Re: MP 07_0158 MOD 2 - Abercrombie Street Precinct
Comments and concerns

Project number: **6423** Drawing number: **A2201** Revision: **F**

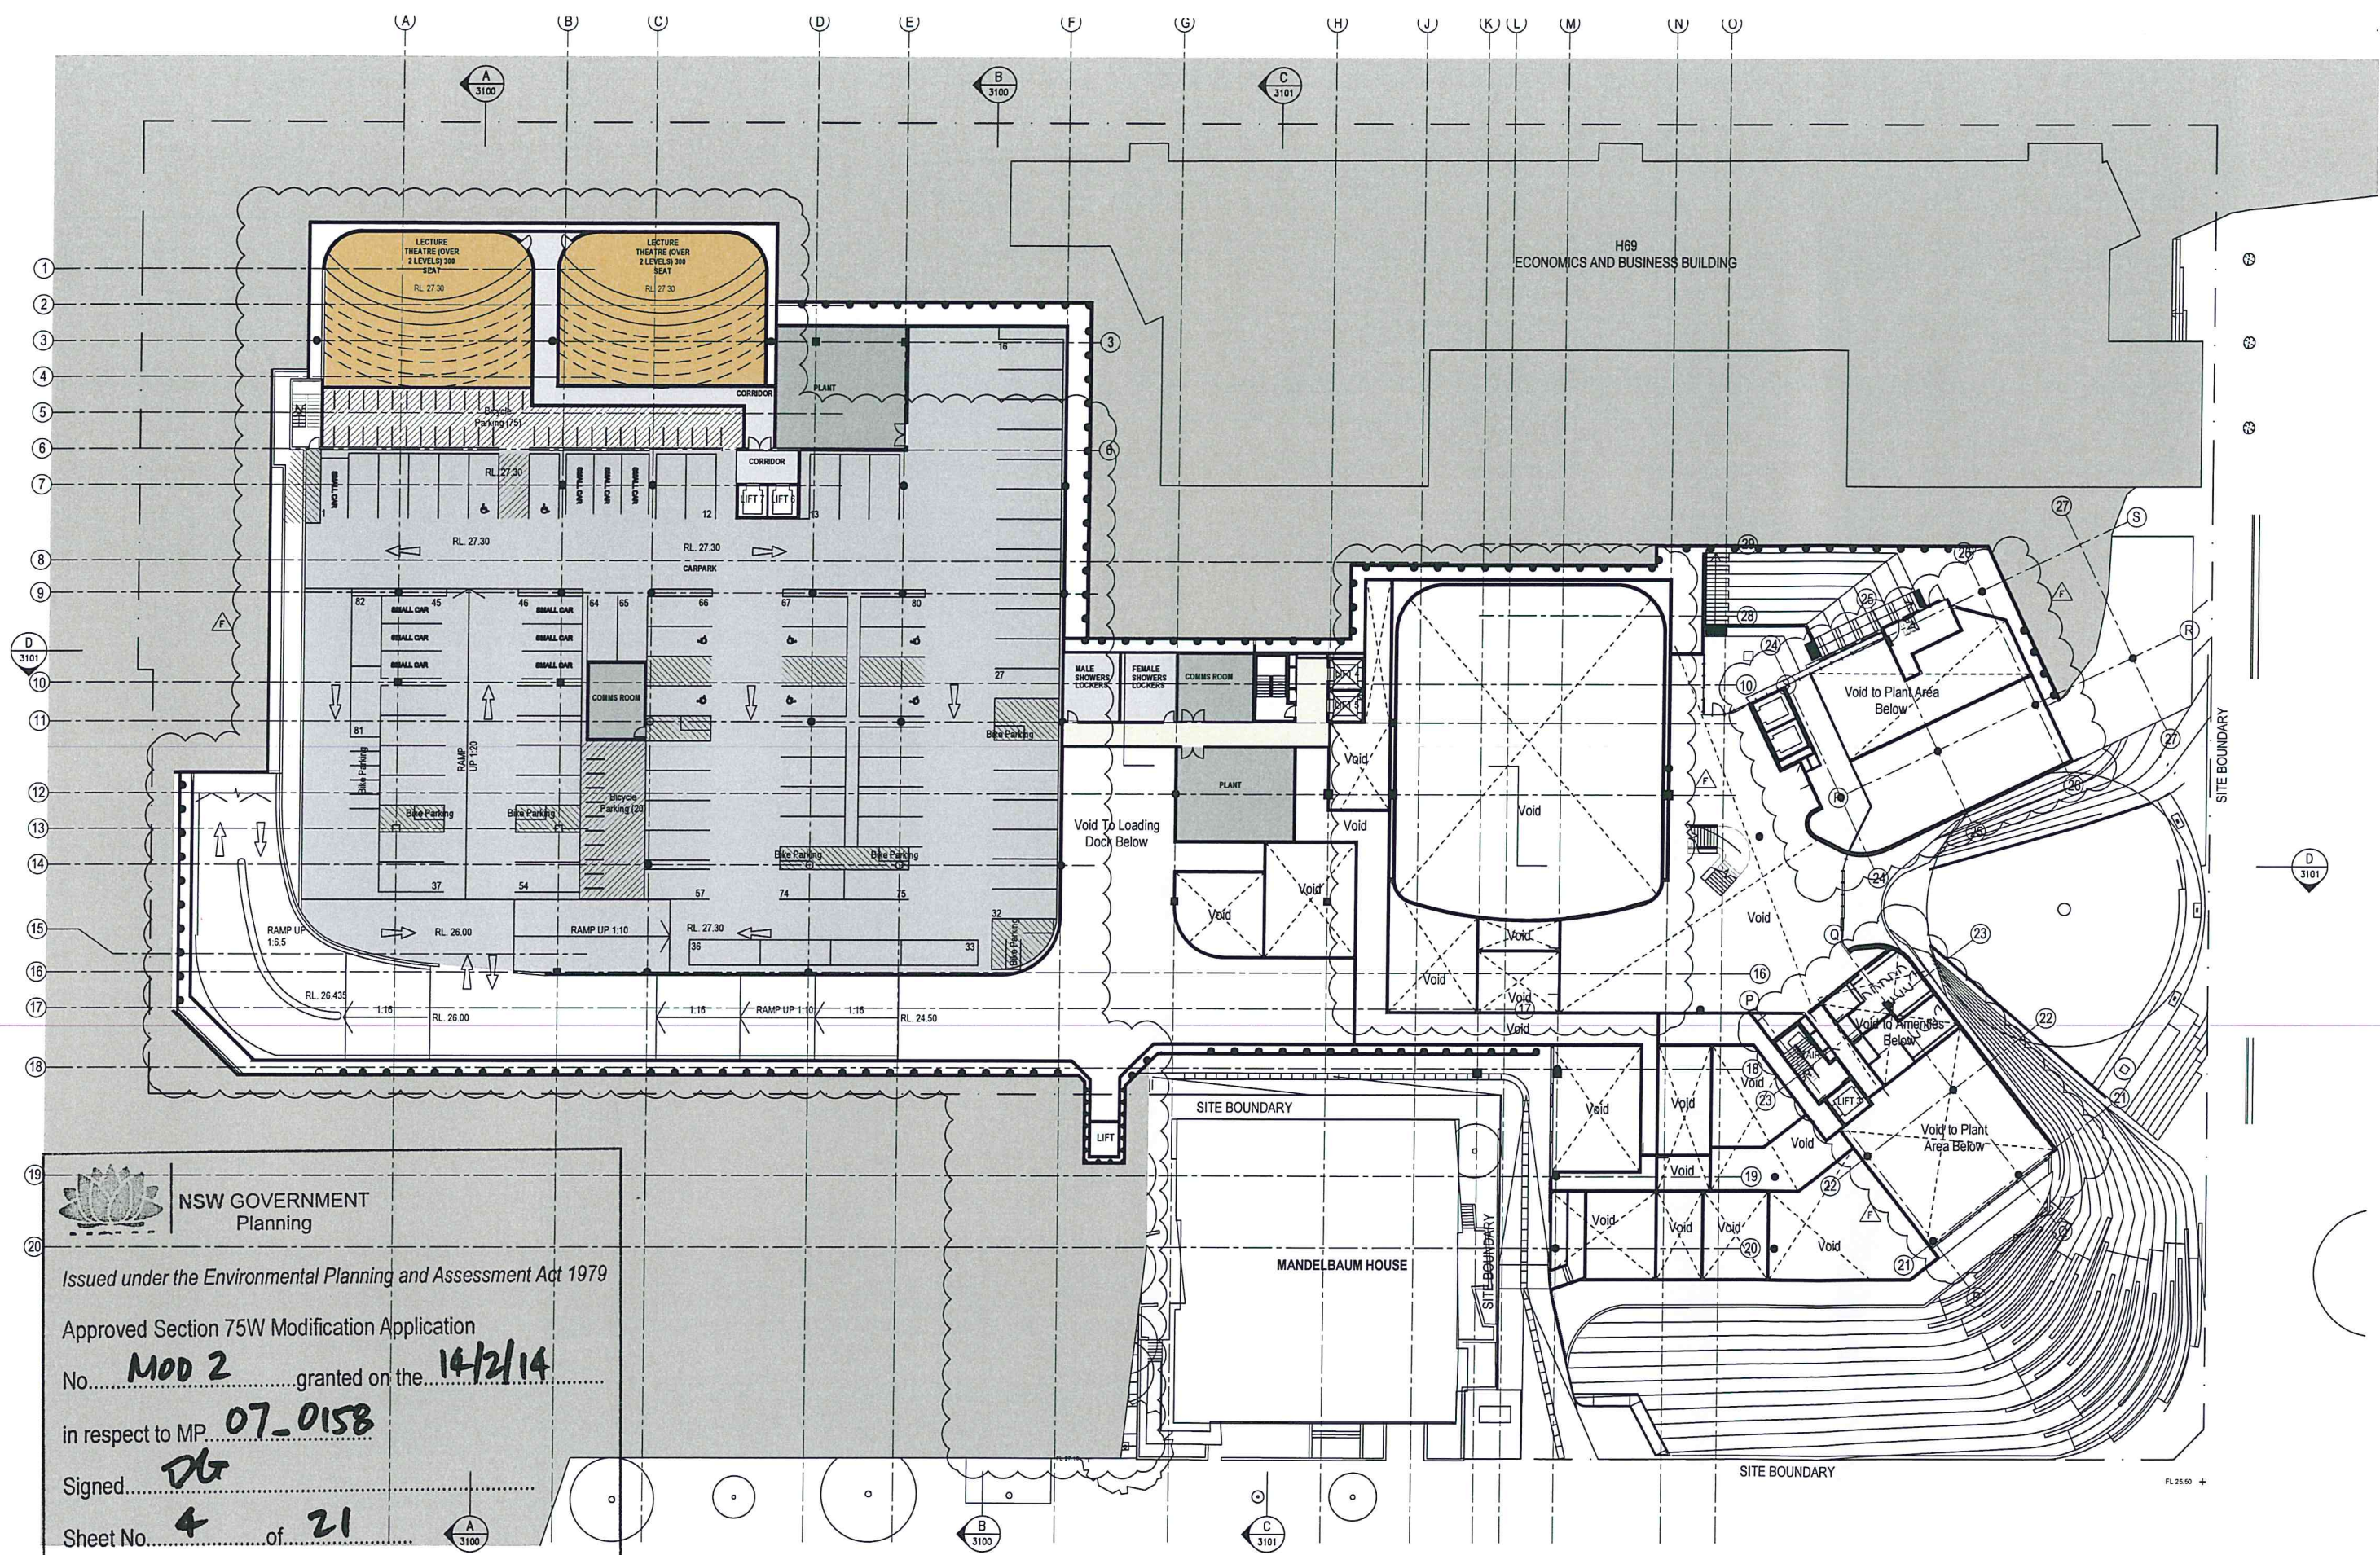
This is also facing directly in front of houses in Abercrombie St. From previous experience with parties on the top terrace at Mandelbaum House, this will cause noise disturbance to residents. The visual screen around the building will not prevent noise spreading. Is this terrace open to the outside? What soundproofing will be provided? We cannot have the noise of screaming kids reverberating around the neighbourhood. I am very concerned by the suggestion that there will be a terrace facing South towards my home. Couldn't it be facing North, which would again provide better exposure and noise reduction?

ABERCROMBIE STREET ELEVATION with context

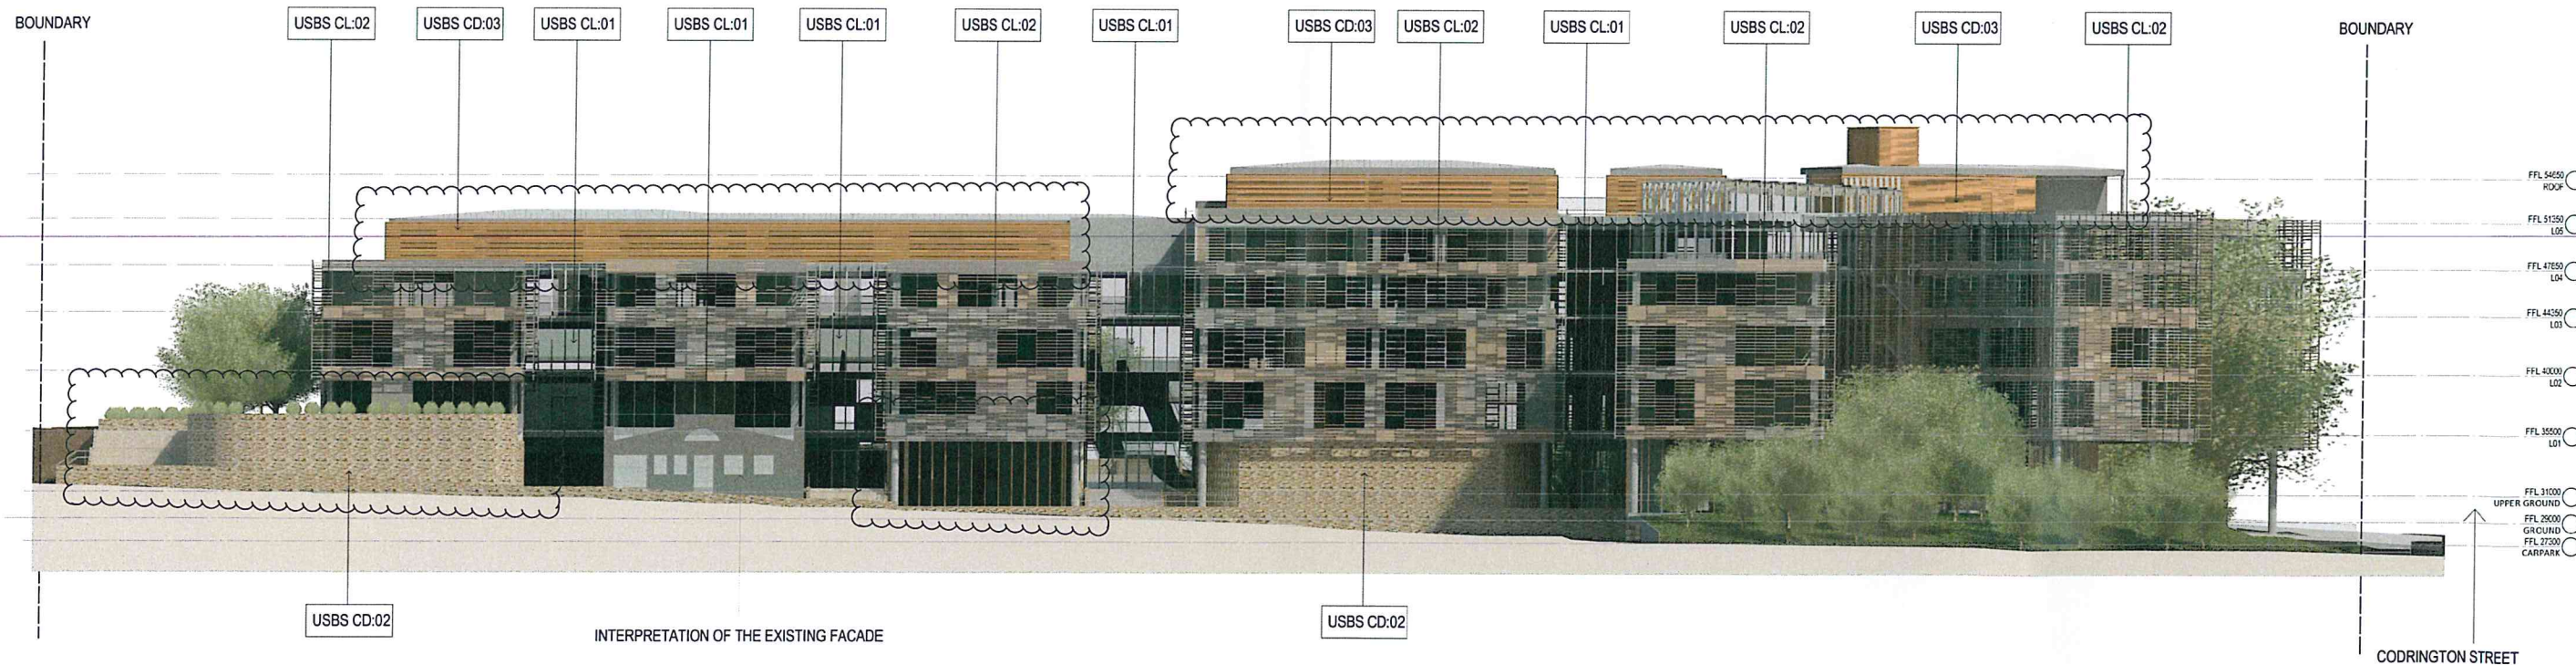
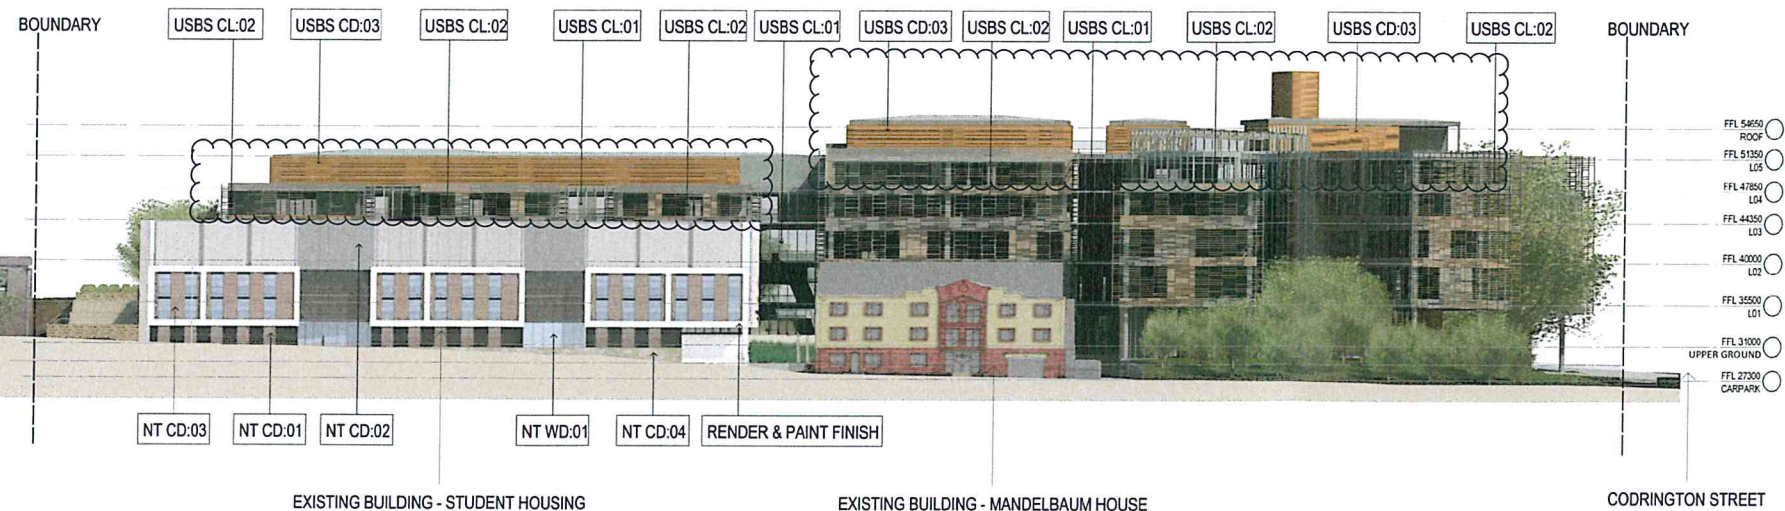
The above drawing (see extract attached) shows that the new building dwarfs Mandelbaum House. As it is directly North, it causes massive overshadowing in winter for Abercrombie St residents, as shown on the diagram, Appendix 5_ KNF-BUS-ARC-DWG-A8002-E-SHADOW DIAGRAMS WINTER

SOLSTICE JUNE 21.pdf. The size and bulk (like gigantic shoe boxes with very busy facade is completely out of character with the streetscape. This horrendous and industrial looking structure must be shielding from the view from Abercrombie St, either by trees or some building along Abercrombie St of similar or lower height than Mandelbaum House, which was a model of what should have been built on this site, facing residential terraces. It completely destroys the character of our street and looks menacing, making us feel like refugees in our street. Furthermore it appears that the building bulk is exacerbated by additional cladding, which not only unnecessarily enlarge the appearance but does not seem to provide protection against noise mentioned above.
